**SSD 10389 MOD 2 – LIVERPOOL HOSPITAL REDEVELOPMENT
REQUEST FOR ADDITIONAL INFORMATION**

On behalf of the applicant, Health Infrastructure, this submission has been prepared by Ethos Urban in response to the Department of Planning and Environments (the Department) Request for Additional Information dated 5 July 2022 regarding the above application.

PROJECT NO.	21807	DRAWING NO.	A-SSDA-MW-34	ISSUE	09
STATUS		<b>SSDA AMENDMENT</b>

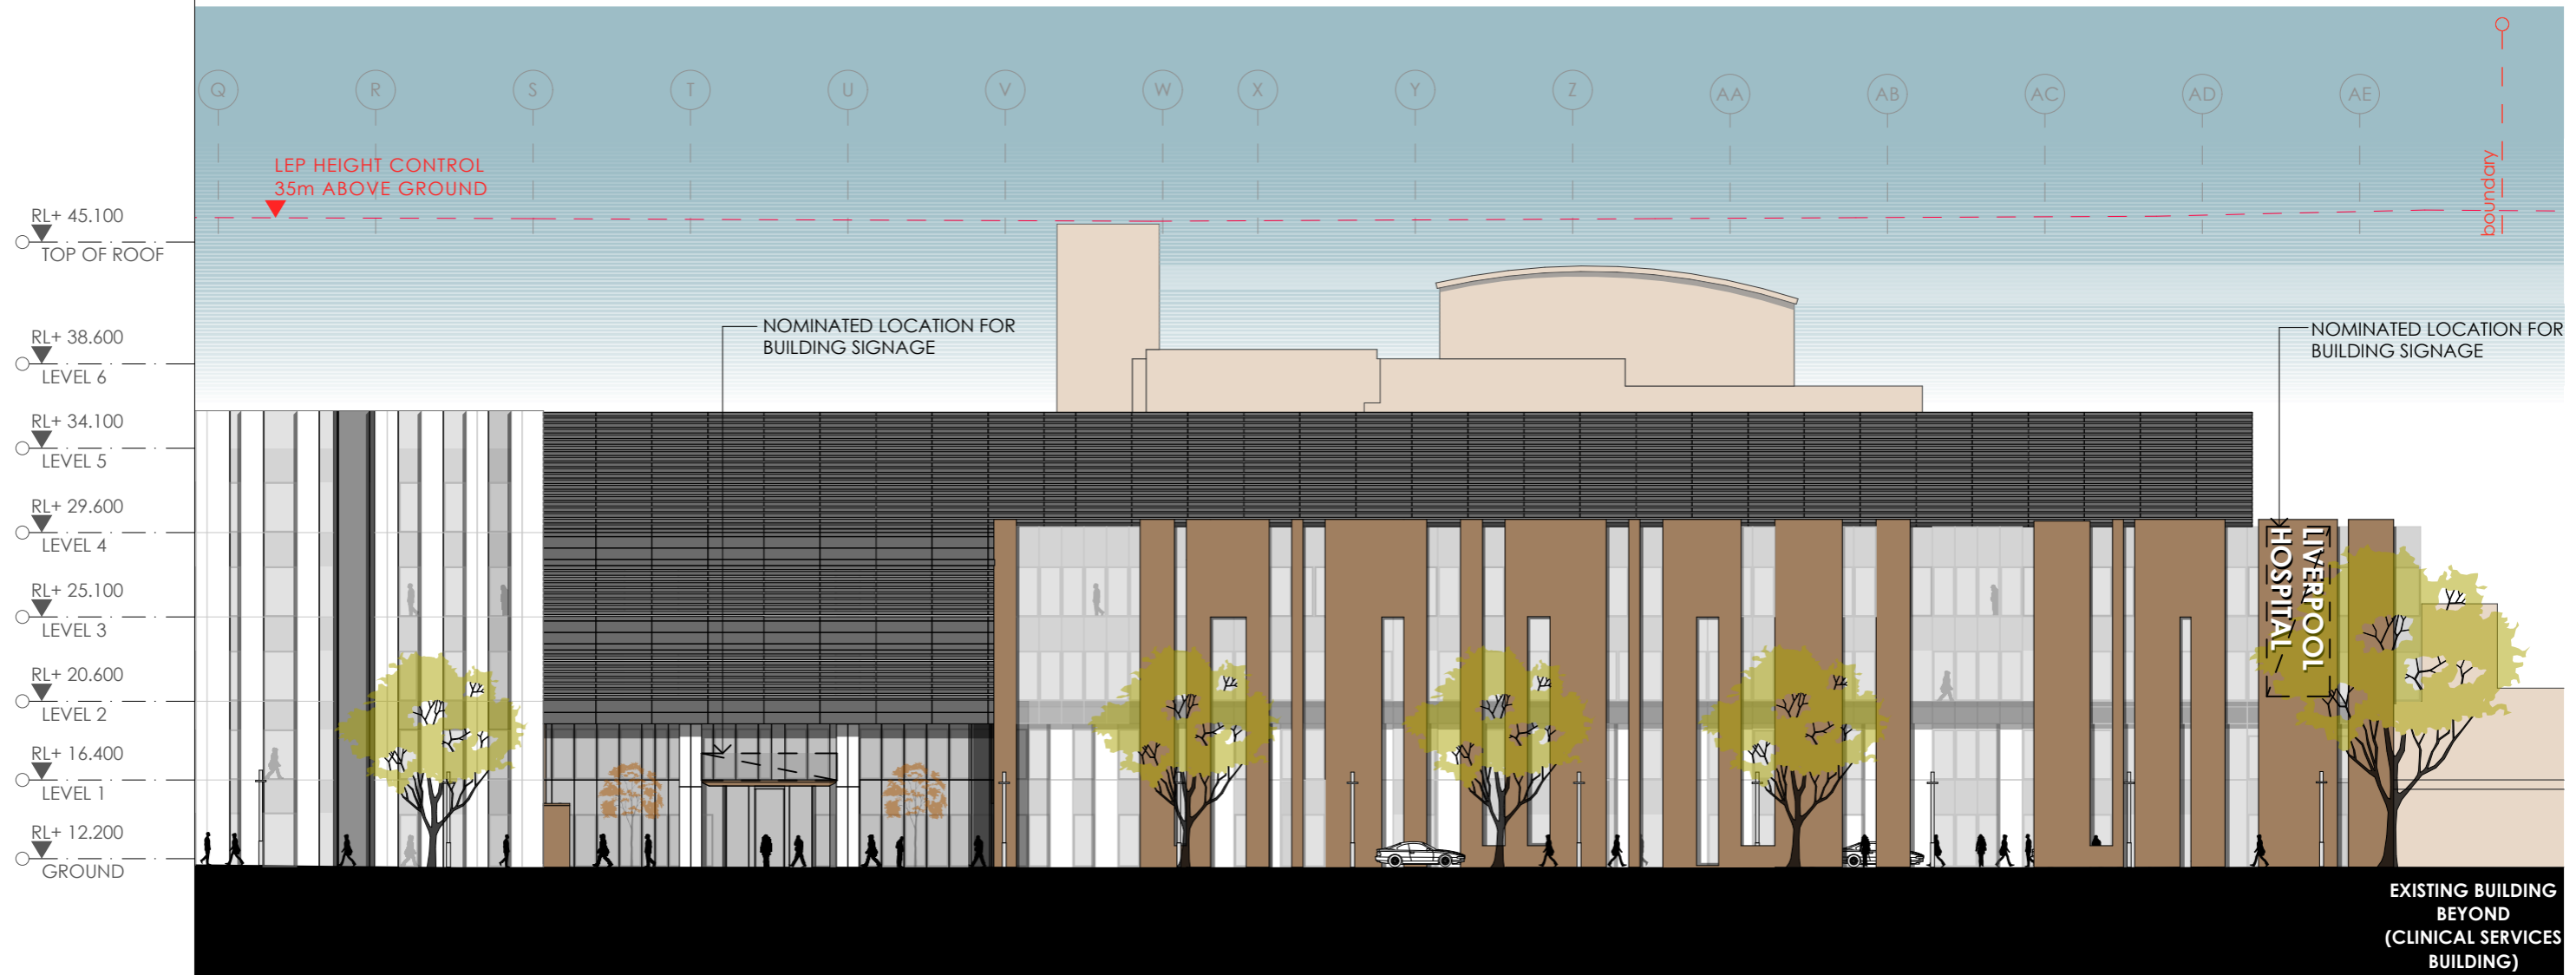
6. The Schedule of Finishes East View shows a laser cut aluminium panel has been selected for the lift lobby. Clarification is required as to whether the design of the laser cut aluminium panel would be identical to the panel along the main entry lobby.	The notation should be 8 (charcoal aluminium panel) and 9 (charcoal aluminium baguettes). An amended Drawing A-SSDA-MW-34 (Issue 11) is attached.
